From: [Pater, Chris](#)
To: [Norfolk Vanguard](#)
Cc: [Fletcher, Will](#)
Subject: Norfolk Vanguard Project - EN010079
Date: 12 March 2019 17:41:07
Attachments: [2019-03-12_Historic England response to PINs_EN010079_Norfolk Vanguard Second Questions.pdf](#)

Our ref: OWF/Vattenfall/Vanguard
Your ref: EN010079

Vattenfall Norfolk Vanguard Offshore Wind Farm: Second Written Questions Examination Registration ID: 20012795

Further to the issuing of the Examination Authorities Second Written Questions on 27th February 2019, we hereby offer the following response to questions that are either directed to Historic England or are otherwise closely associated with our responsibilities as Historic England.

Seabed features of archaeological potential
in Norfolk Vanguard West

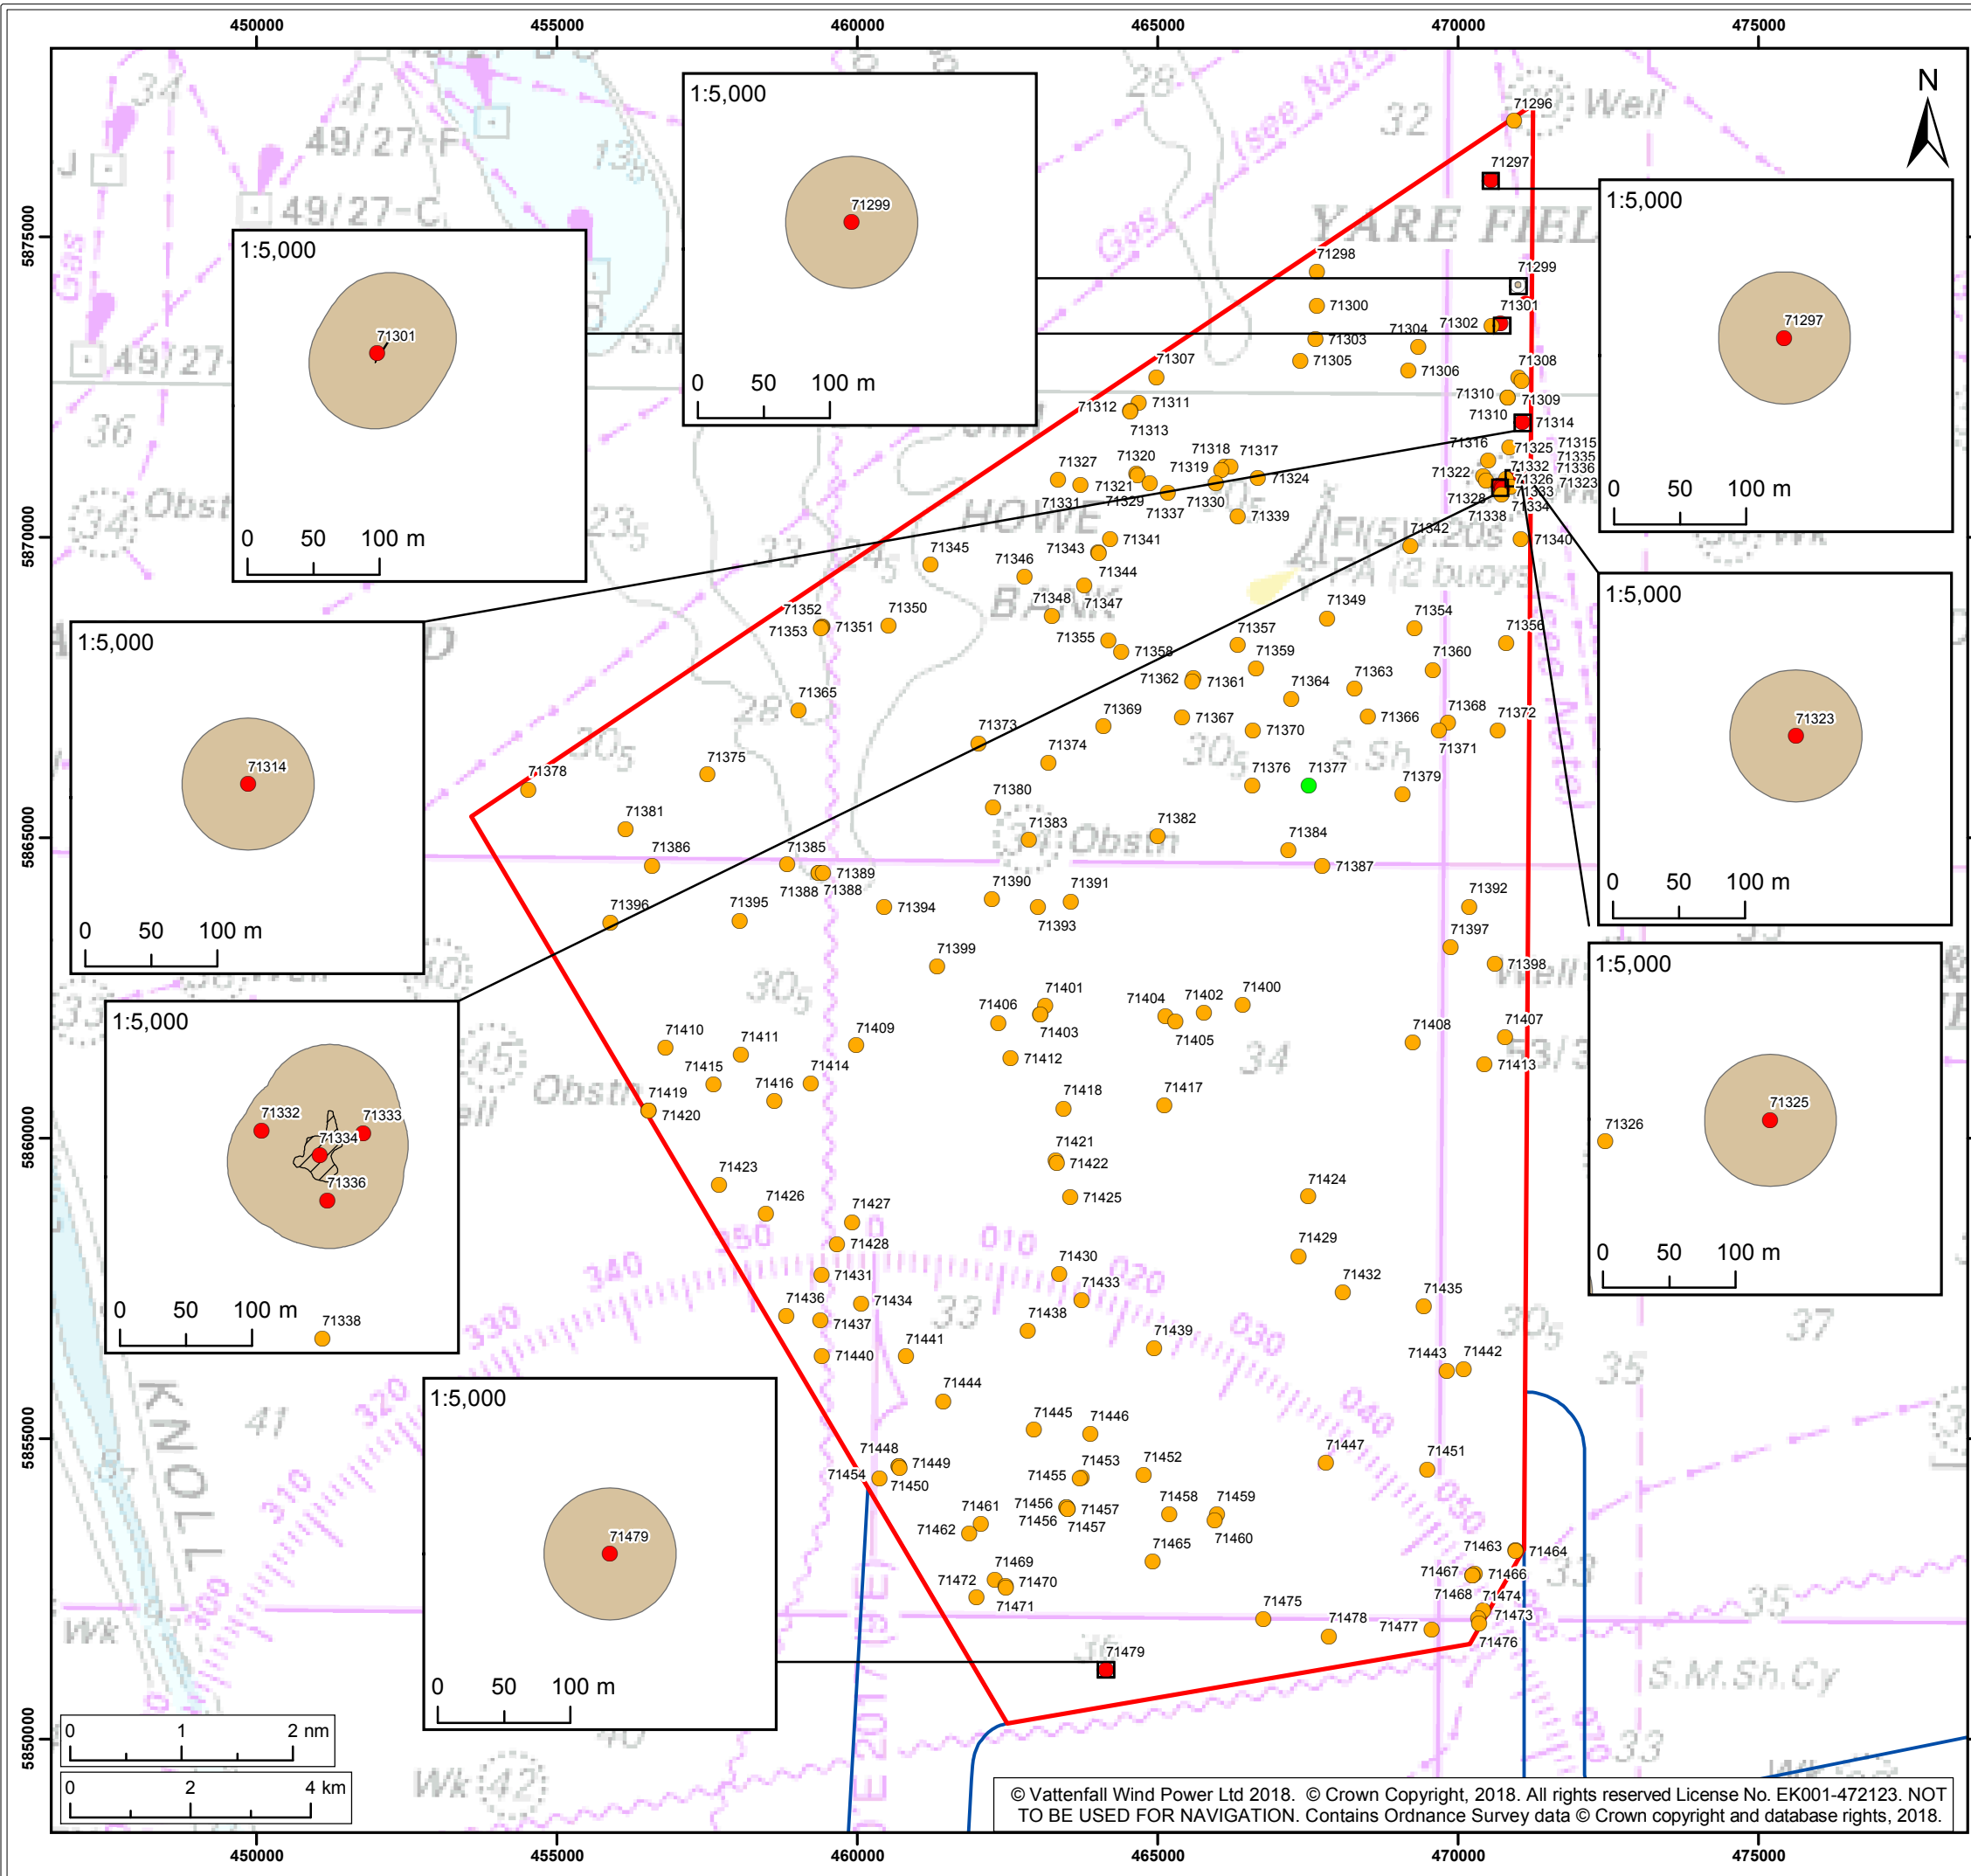
17.7.2) that 50m AEZs are used around the extents of identified and/or known wreck sites (classified as “A1”) and 50m Archaeological Exclusion Zones (AEZs) are used around the point locations of “A1” magnetic only anomalies, we support this strategy of avoidance, such that no development related activities will take place within any identified “A1” AEZs.
